27th August 2019

Construction of 9 no. dwellings, access, landscaping and associated works.

Land adjacent to Scyld Horsemere Green Lane Climping

Thank you for your internet representation made on 26th August 2019 which has been recorded as '**an objection**' with the comments as follows:

FIGURE 1.3

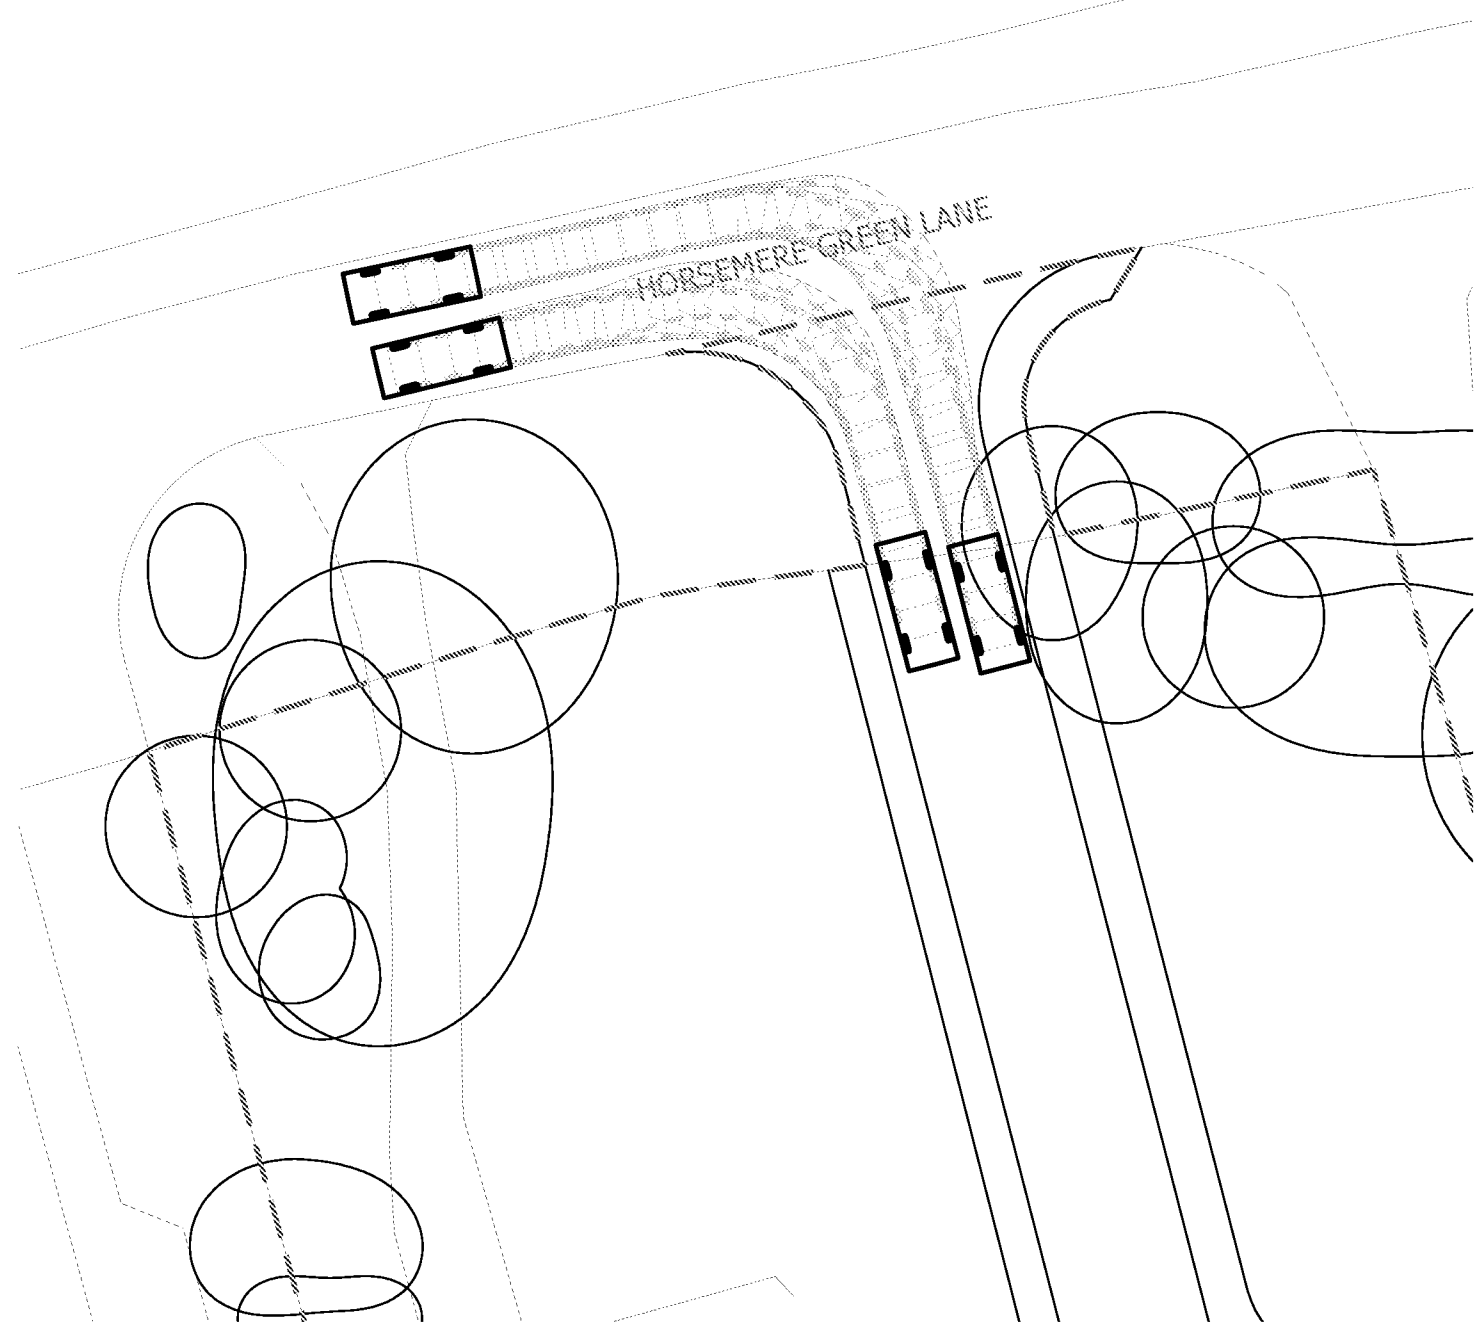
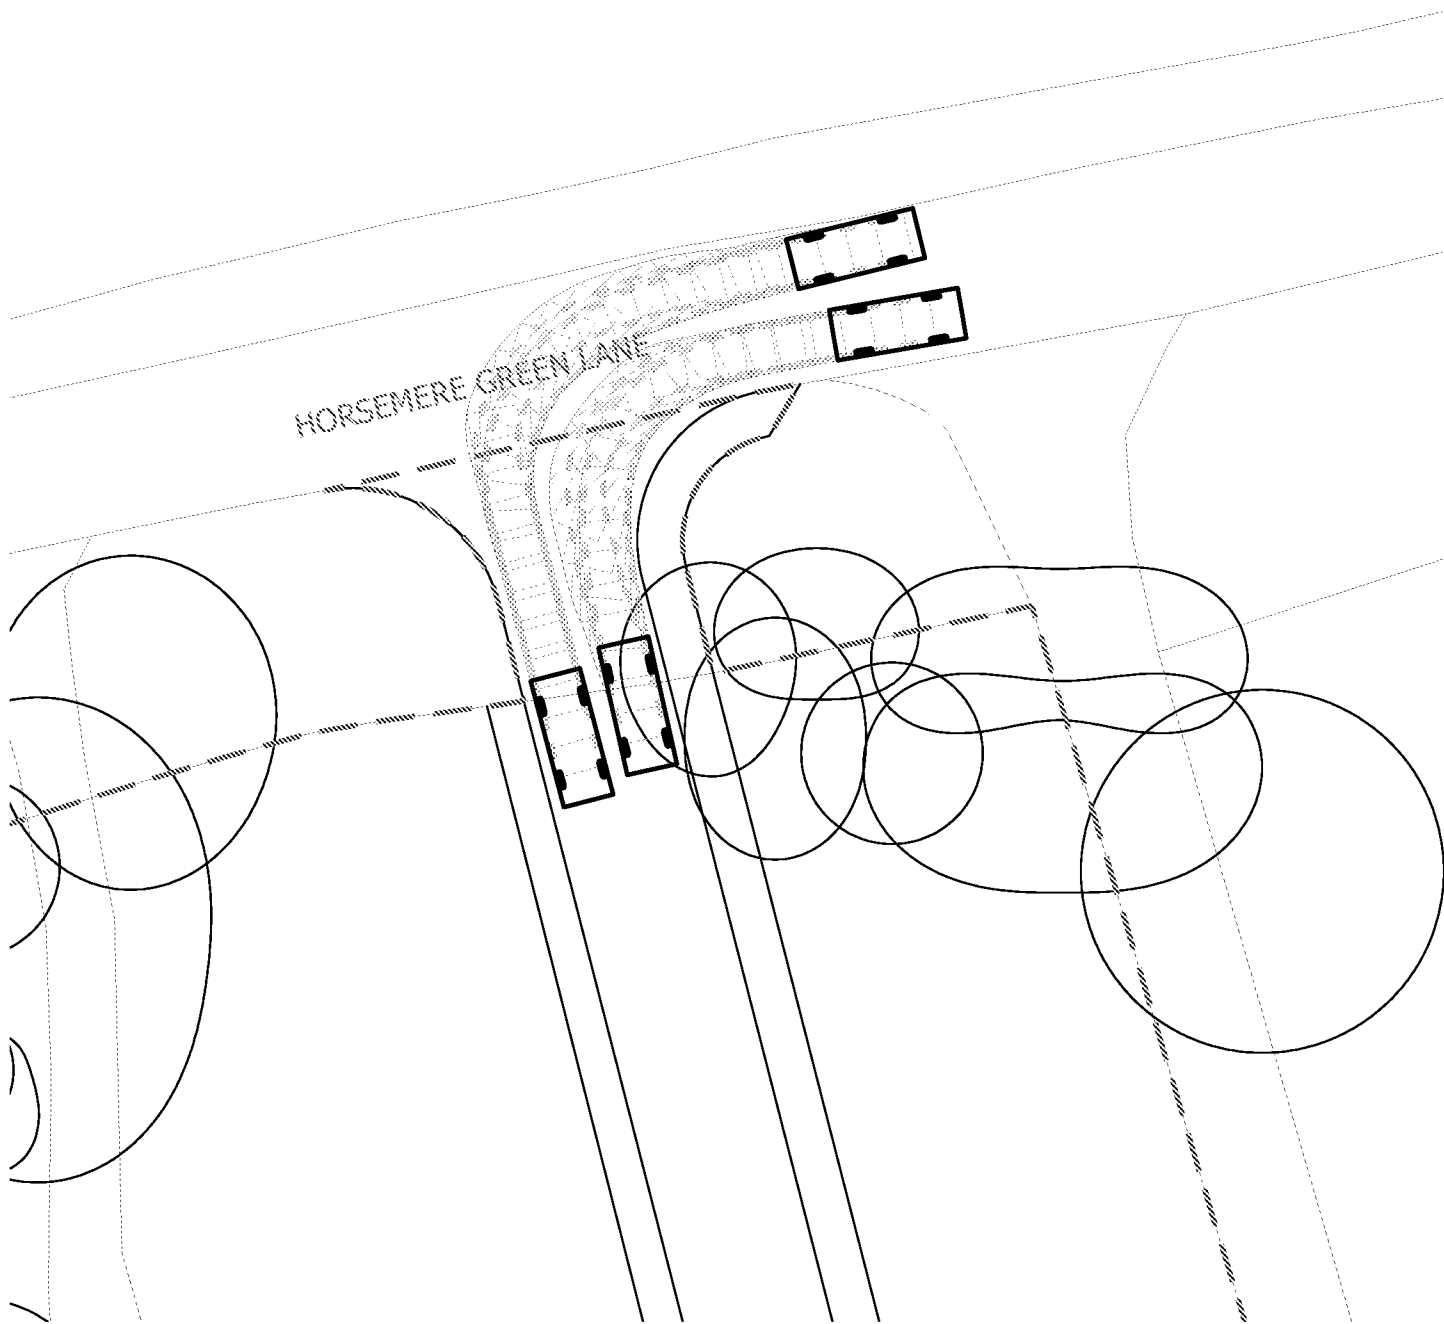
I keep wondering how a safe entrance will be established on Horsemere Green Lane given that the site access shown on the plans is between two other entrances within 10 metres. Furthermore the plans seem to show the entrance widening over the boundary of the adjacent property so looks incorrect.

FIGURE 1.6

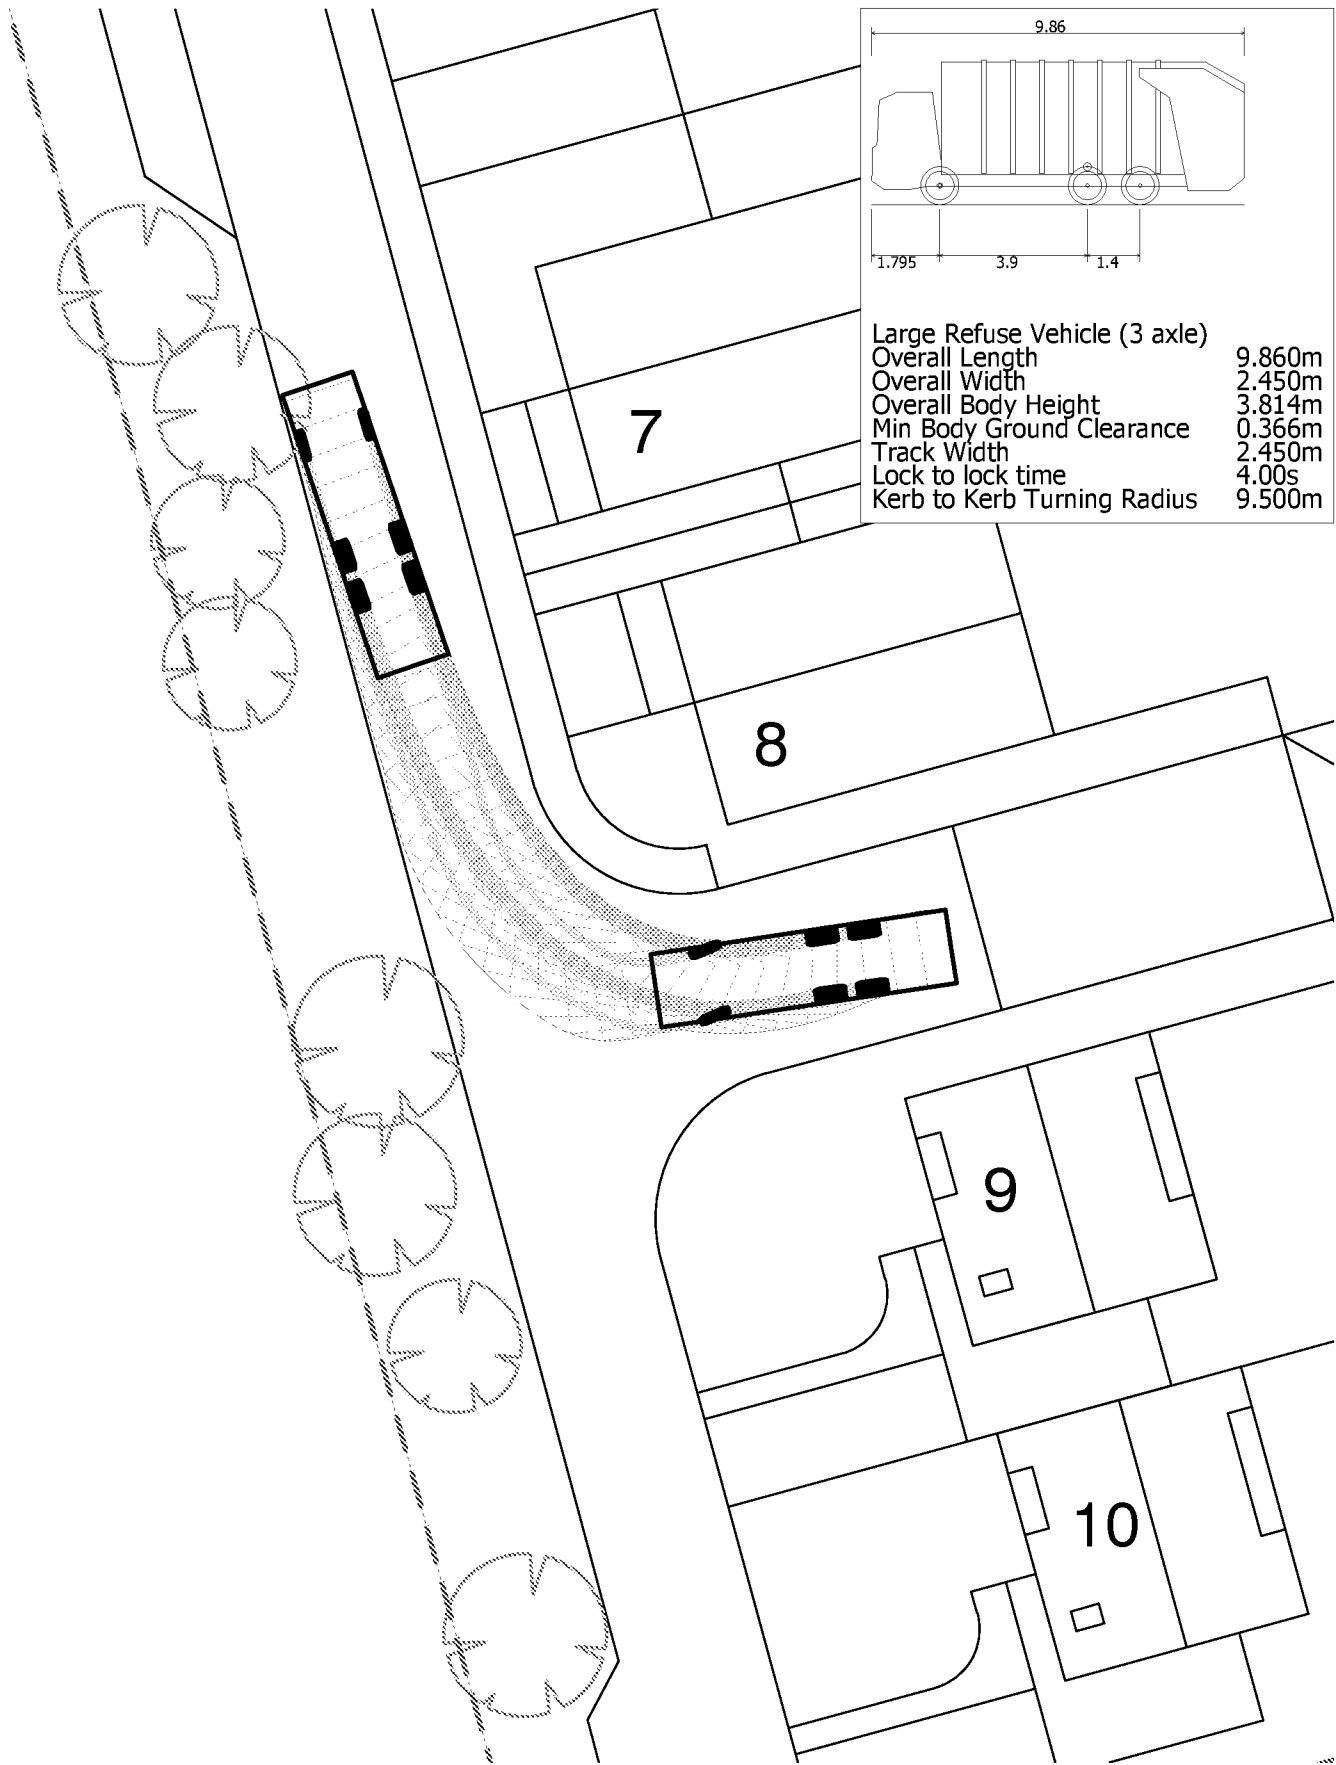
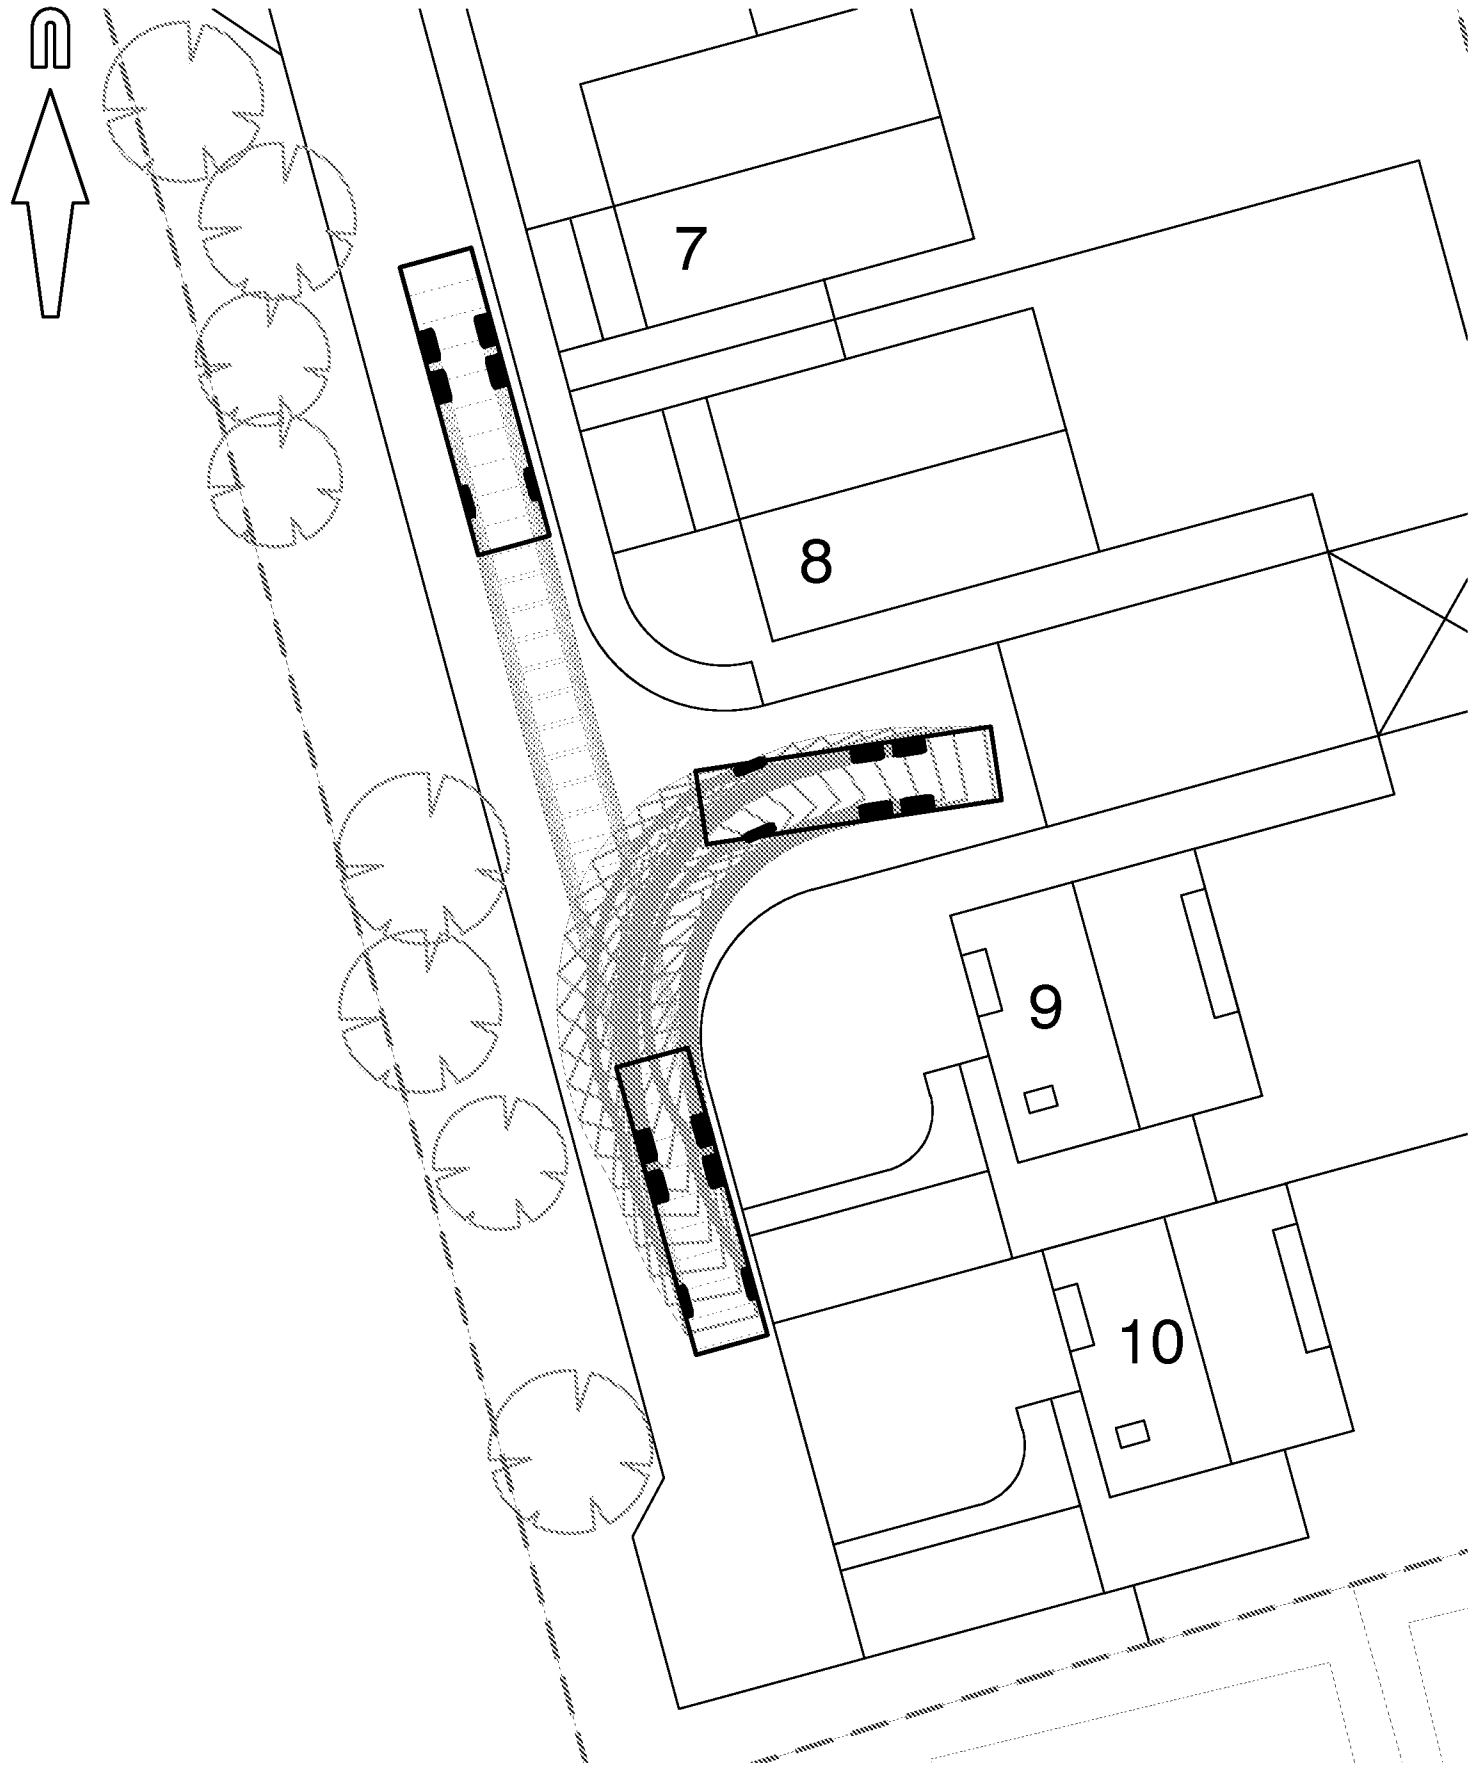
Any ambulance/fire engine/bin lorry/delivery would be forced to enter the opposite carriageway in order to enter the site...how can this be deemed safe when speed restrictions are in place on a road that is already a rat run? How about the fact that there are no double yellow lines in HGL to stop parking? With these 9 houses, 2 more adjacent, 300 in the pipeline and more to come at neighbouring sites how is this considered safe? It is inevitable that parking will spill over as the site has some 54 bedrooms and these days that almost means 36 cars!
